**Consultation Response from KC,  
Highways Development Management**

**2021/93565 Land Adjacent, Hazeldene House, Stoney Bank Lane, Thongsbridge, Holmfirth, HD9 7LZ**

**Removal of condition 5 (Construction Method Statement) on previous permission 2020/91213 for erection of detached dwelling and formation of new access (modified proposal)**

**Responding Ref:  
K12-6/2**

Description: **PROPOSED CONSTRUCTION MANAGEMENT PLAN**

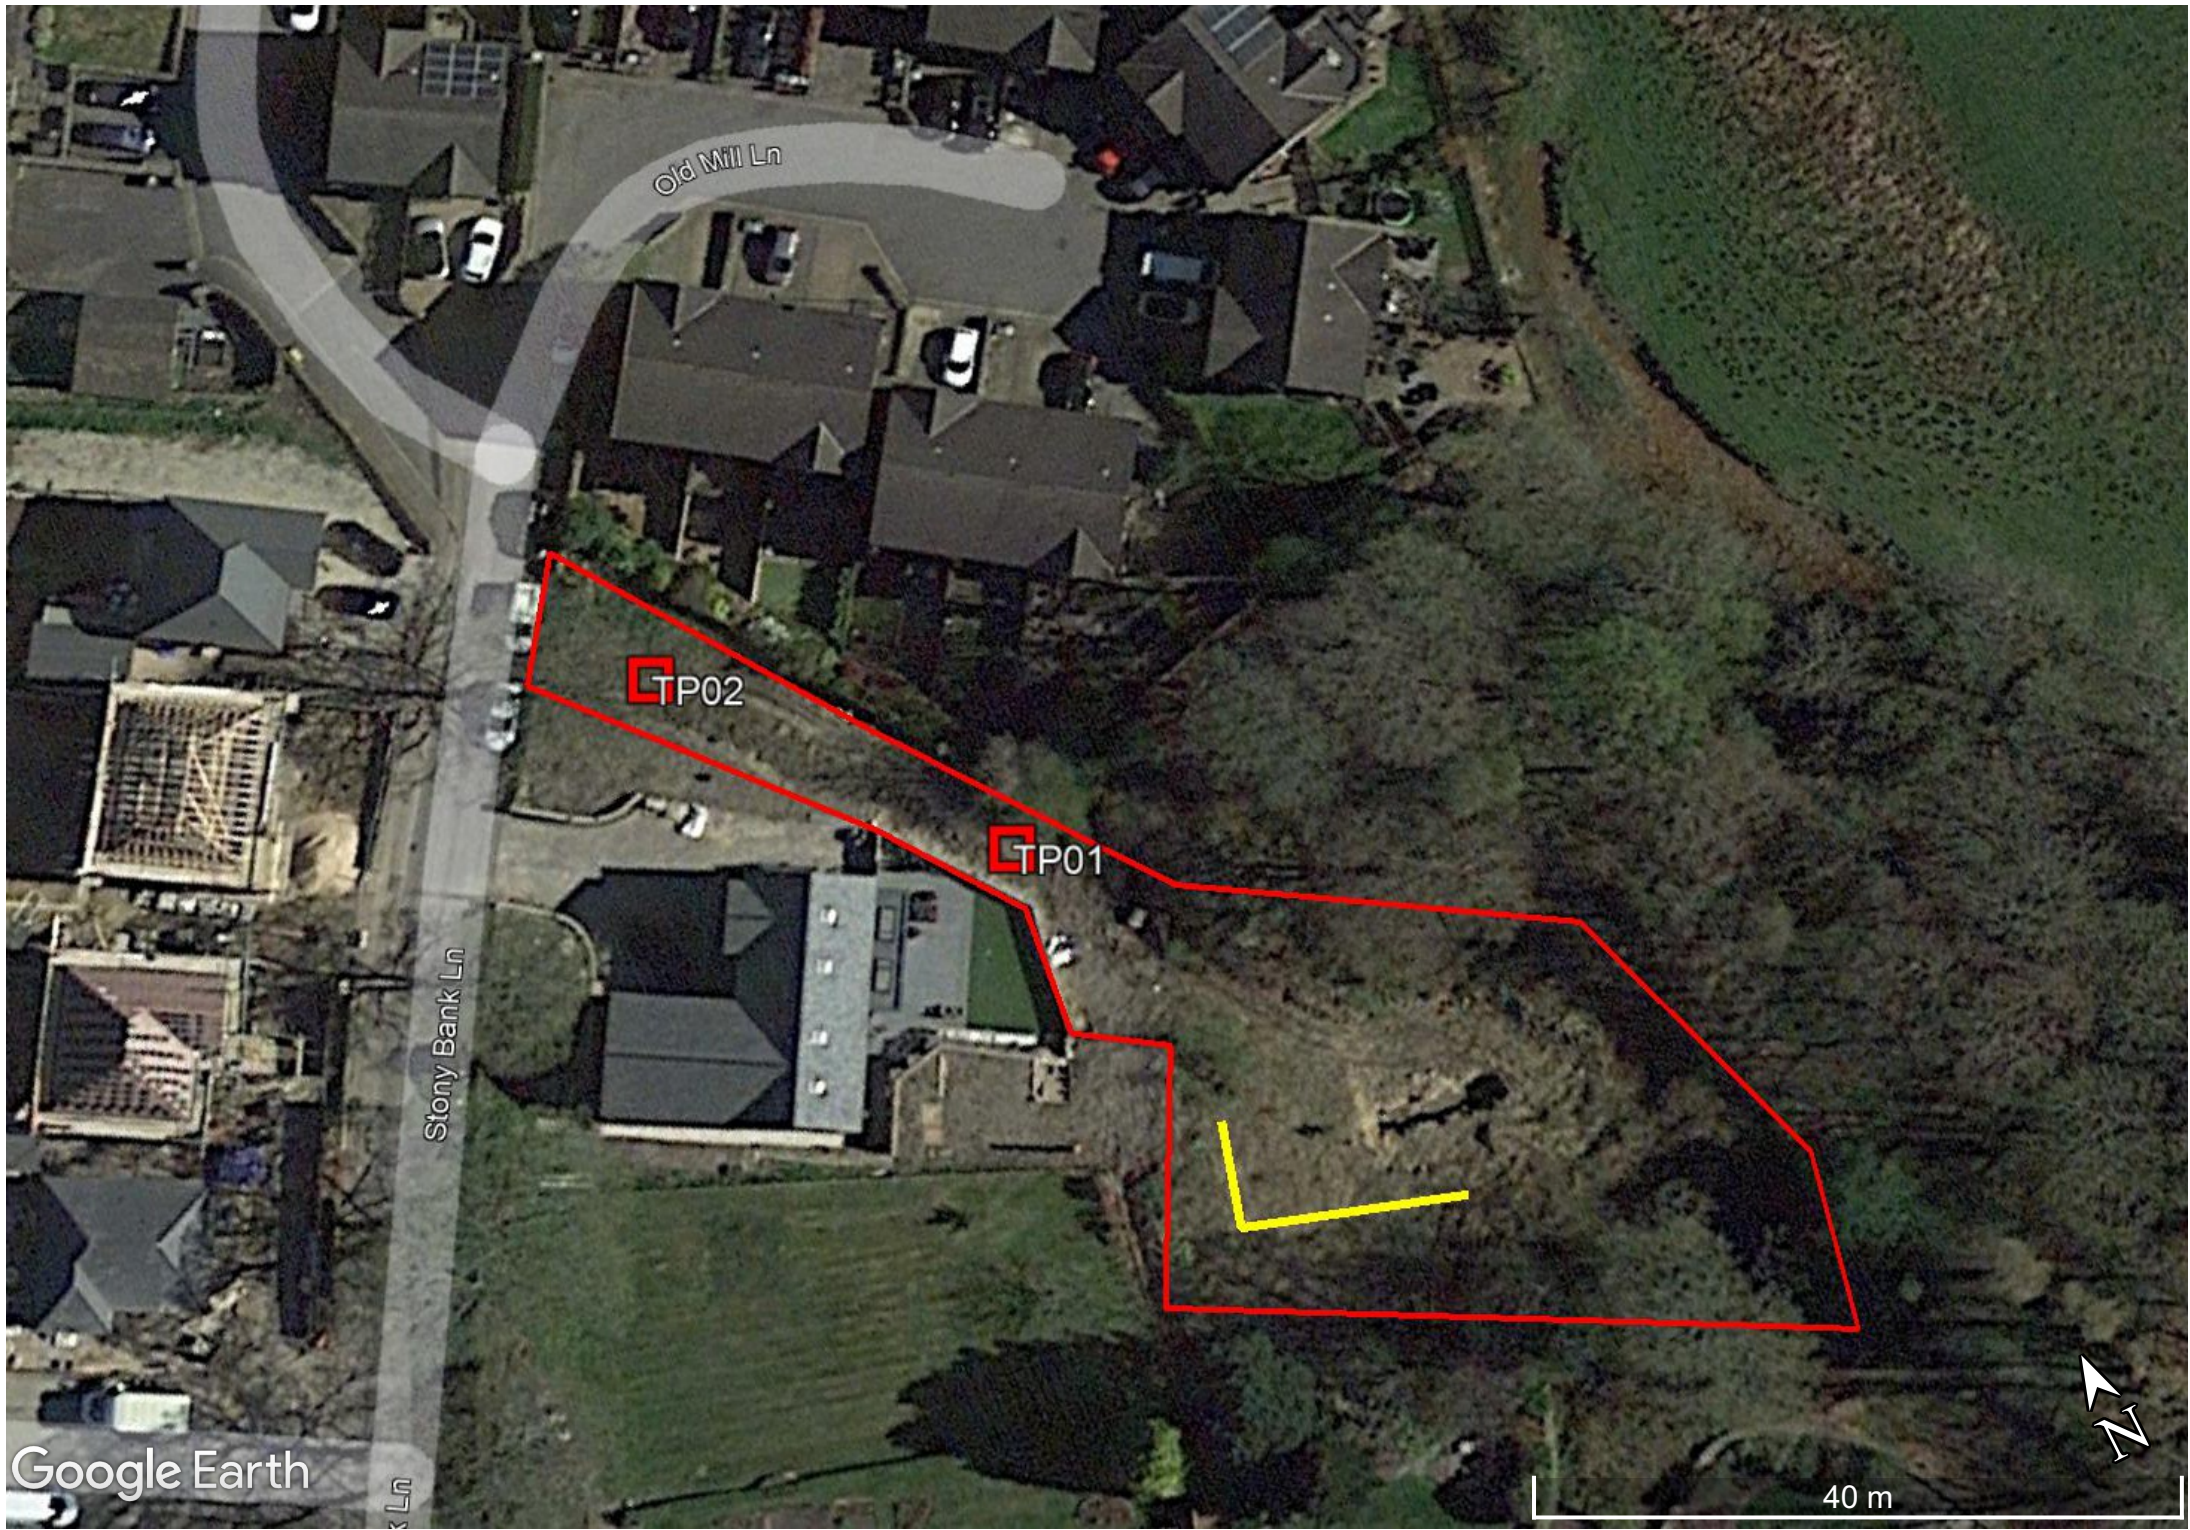
The applicant has submitted a construction management dwg/plan (ref L(100)10) dated Sept 21, contained in the submissions is the required information to satisfy condition 5 to be removed subject to the applicant adhering to the requirements contained within said submissions.

HDM consider the information provided acceptable, condition 5 can be discharged as required.
